March 17, 2022

JN 19233

Subject: **Review of Plans**
Proposed Day Residence Reconstruction
9843 Mercerwood Drive
Mercer Island, Washington

A1.1

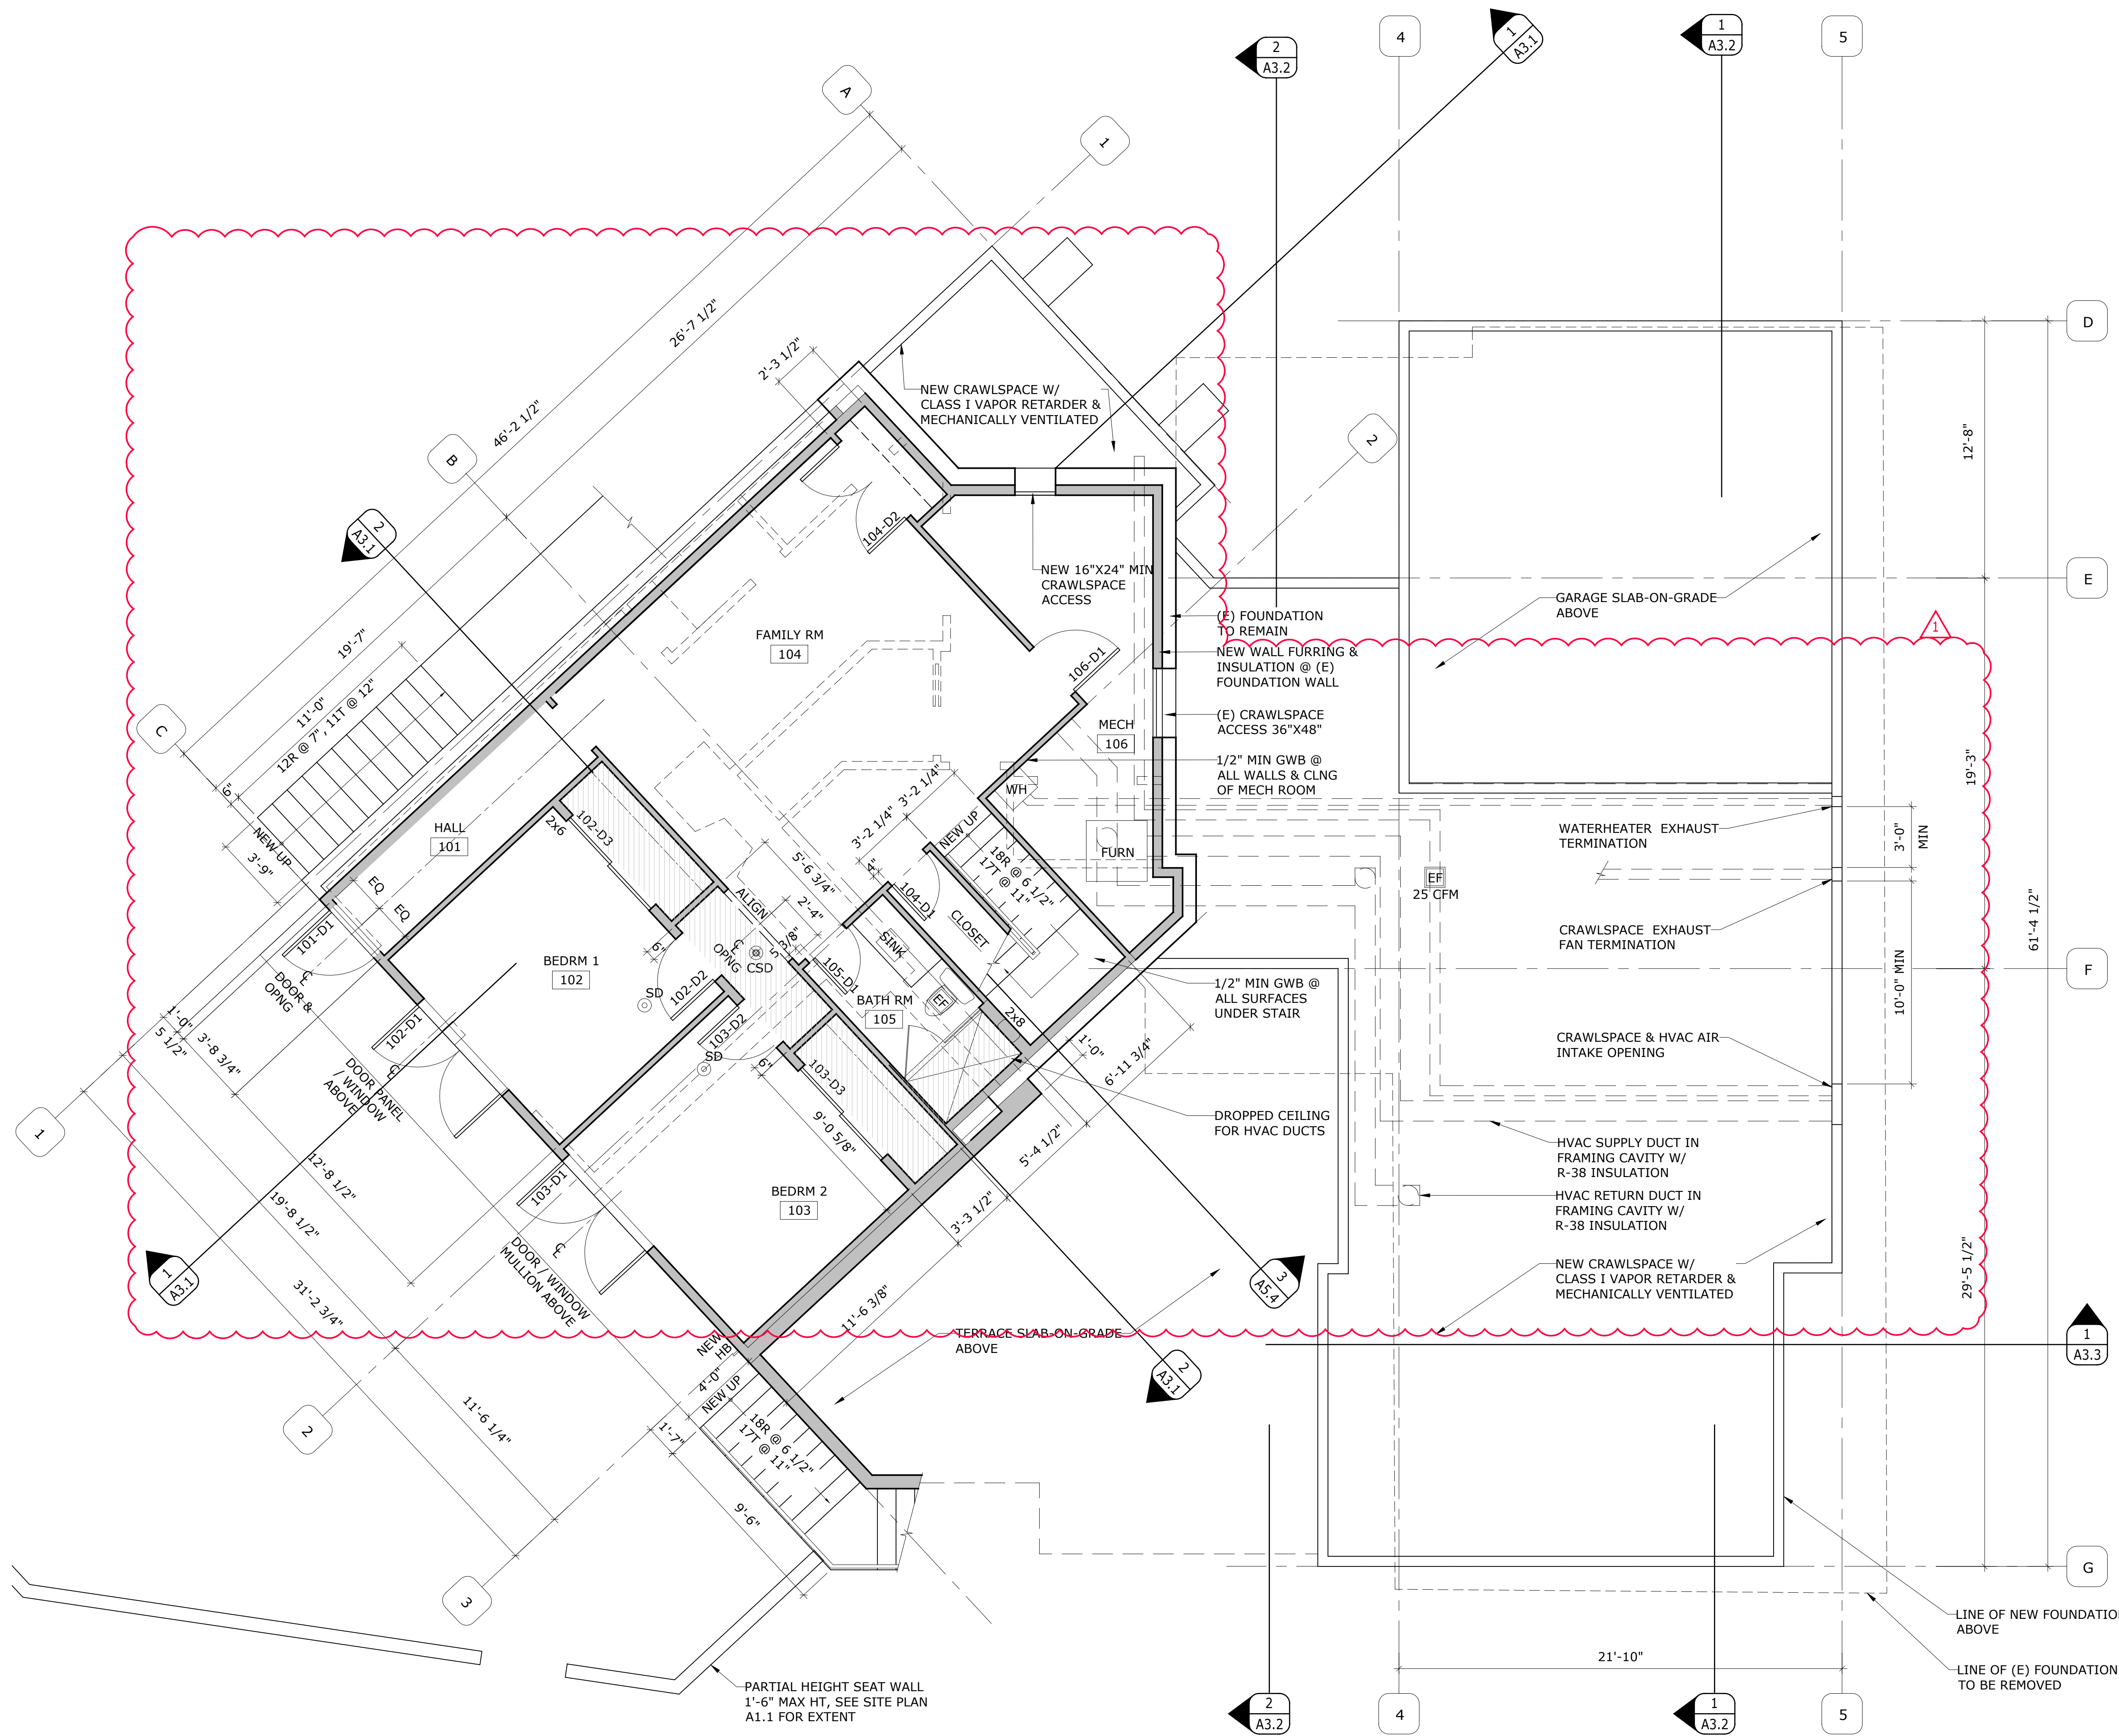
In response to **Geotechnical Comment 2**, as indicated on sheet A1.1, the existing rockery will now be removed where it extends into, or beyond, the footprint of the proposed terrace retaining wall. This will remove the hazard presented by the small section of existing rockery currently located at the top of the eastern slope. The ground will be sloped to a flatter inclination following the removal of the affected section of rockery, and the regraded area will be landscaped. This work will reduce the surcharge at the top of the steep slope currently imposed by the rockery, and should not adversely impact the stability of the slope.
